AQUIND INTERCONNECTOR

Applicant's Response to Local Impact Reports

Document Ref: 7.7.13

DATE: 20 OCTOBER 2020

AQUIND Interconnector Sheet 9

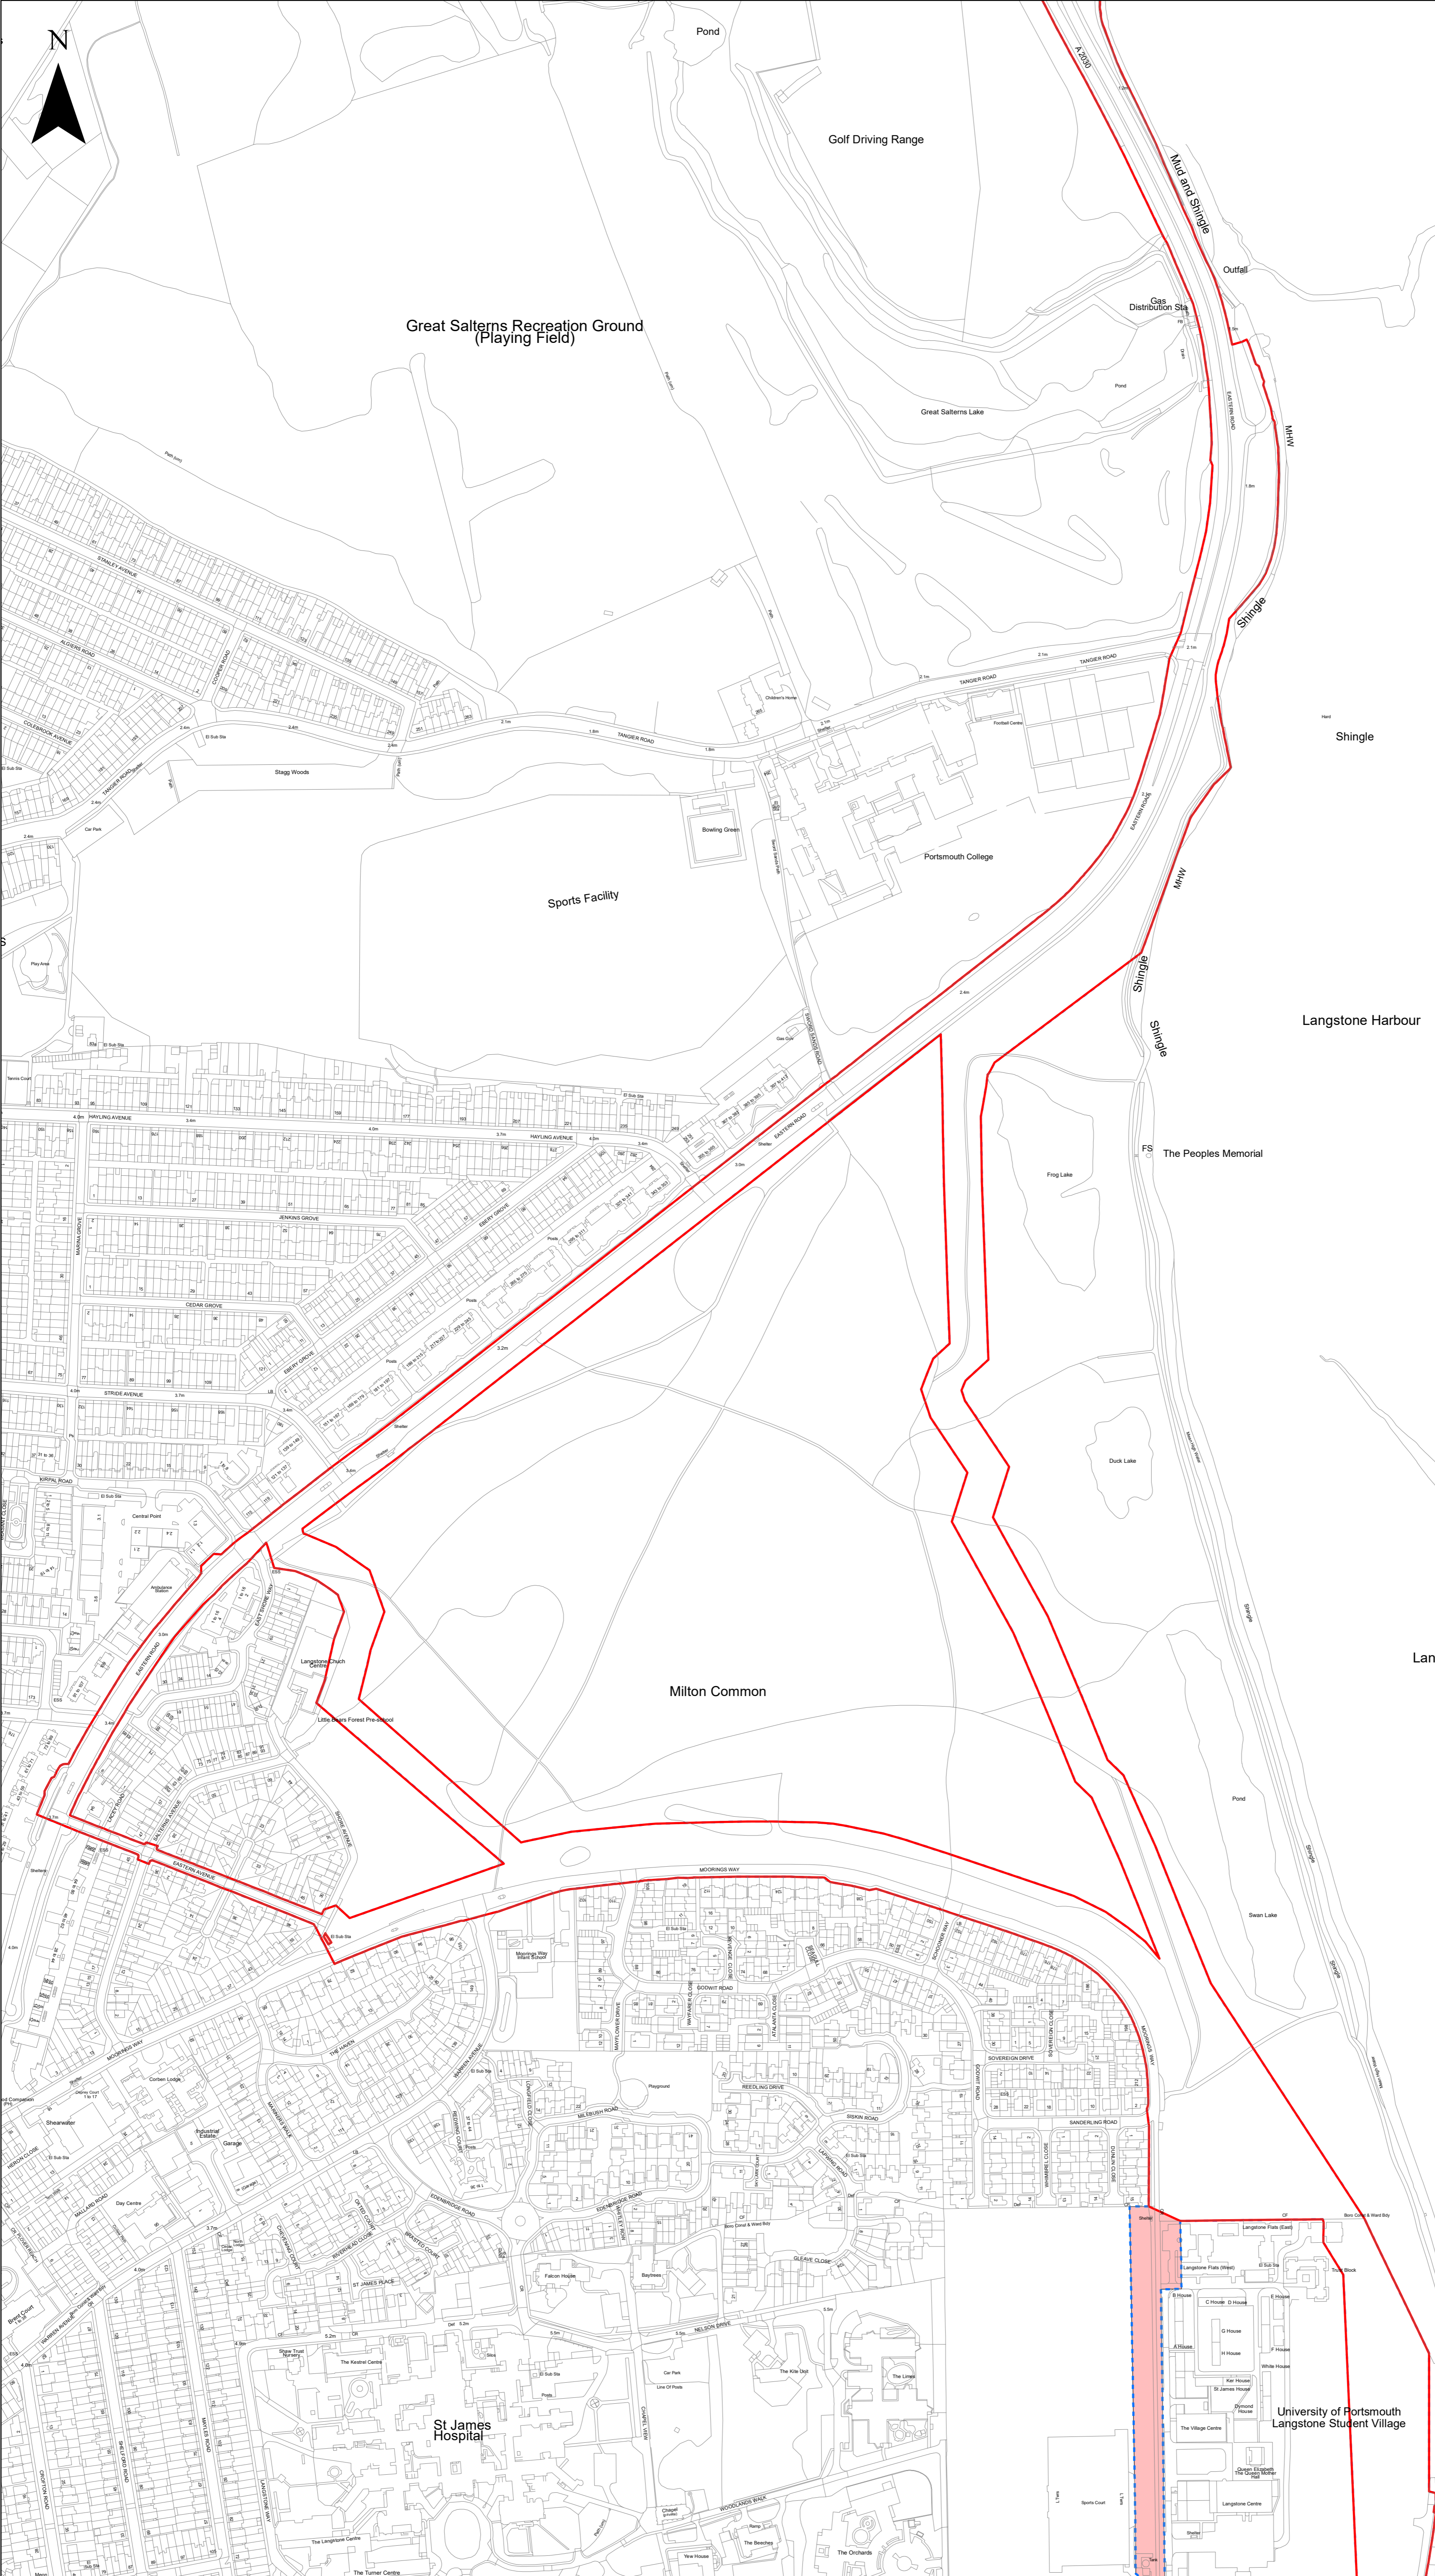
3.9.5	There is a third route option noted on the Land Plans (EN020022-2.2-LPSheet9) which utilises the A2030 Eastern Avenue southward to its junction with Eastern Avenue and Moorings Way to bypass the Common completely. This would result in added congestion on a main arterial road A2030 into Portsmouth but would have little effect on Milton Common apart from access.	<p>Highway impacts are assessed within ES Chapter 22 Traffic and Transport (APP-137) and ES Addendum, and further considered in the Supplementary Transport Assessment (REP1-142), which at section 5.4 includes an Assessment of Eastern Road. The traffic management measures required to facilitate construction of the Onshore Route in this section are provided at section 10 of the Framework Traffic Management Strategy (REP1-068).</p> <p>Further information regarding the approach to selecting the option to install the onshore cables in the vicinity of Milton Common is provided in the Position Statement in relation to the refinement of the Order Limits (REP1-133) and the response to ExA WQ CA1.3.18 (REP1-091).</p>
